Please upload the email below from **Environmental Health** onto Ocella for **LU/90/20/DOC** – Parcels A2 and B6, Hampton Park, Littlehampton.

Environmental Health:

Condition 22 - Construction Management Plan. CEMP Version 4. I note that this document removes the previous reference to mechanical piling provided in Version 3 and presume that this is because no such operation will be necessary on this site.

Drawing No. 544_PL_CMP – Phase 3 Construction

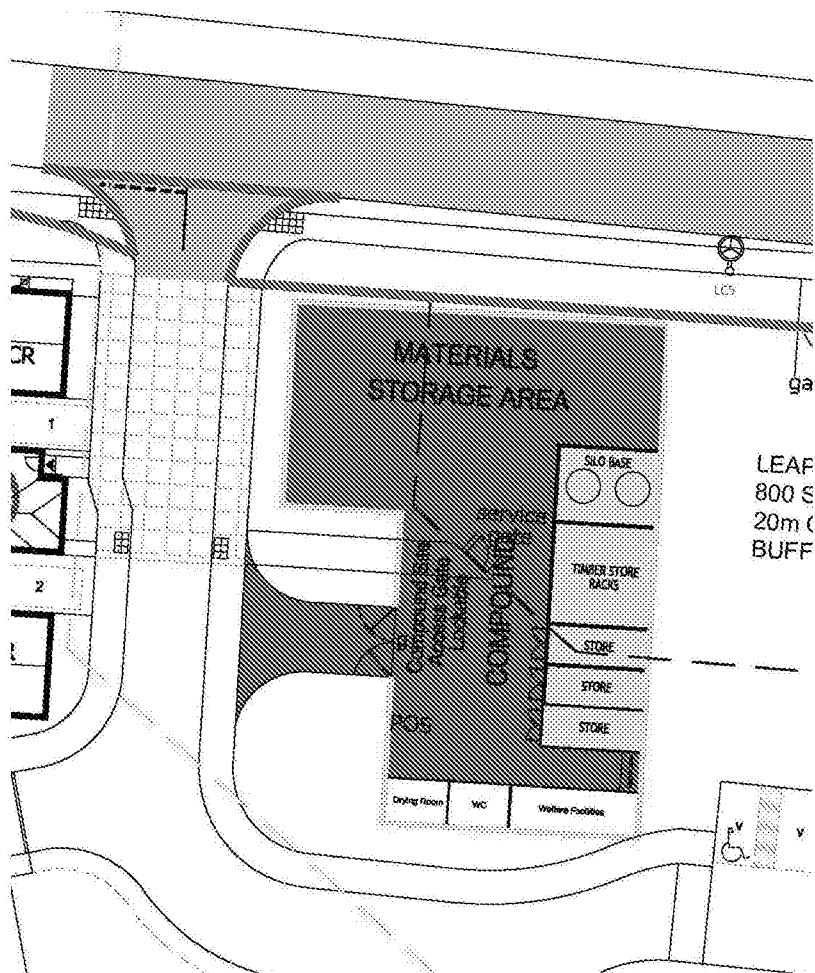
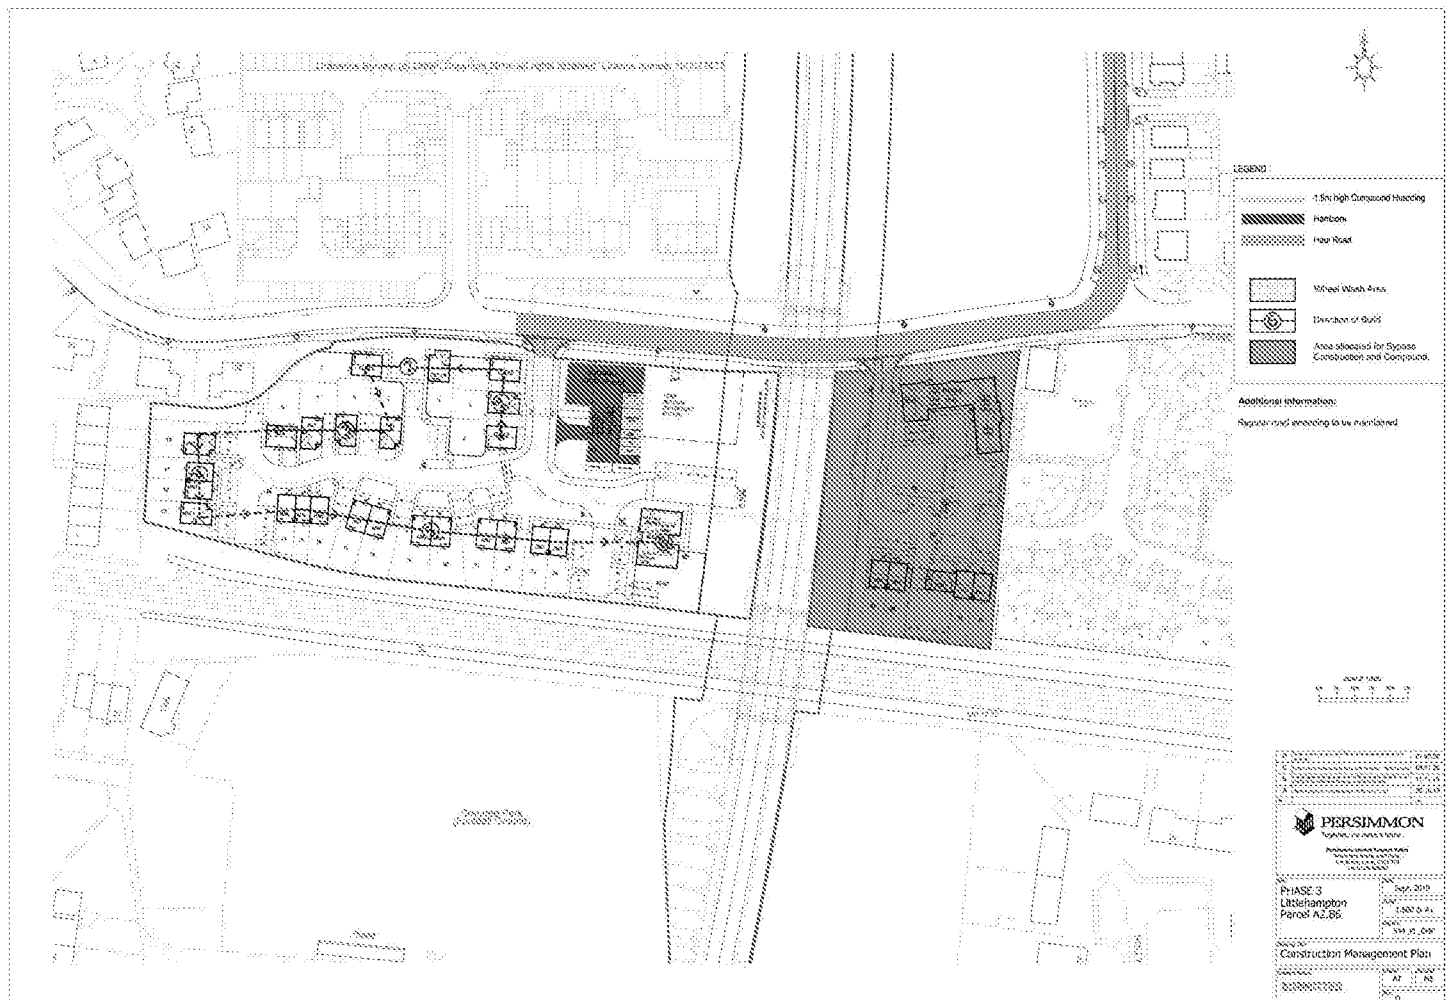
Condition 23 - Construction Compound. I note that a buffer zone will be provided to Parcel B6, which is defined in Appendix C of the CEMP relating to the southern section of the Lyminster By Pass. This is in order to protect the amenity of sensitive receptors already built to the east of this site.

Agree discharge of Conditions 22 and 23
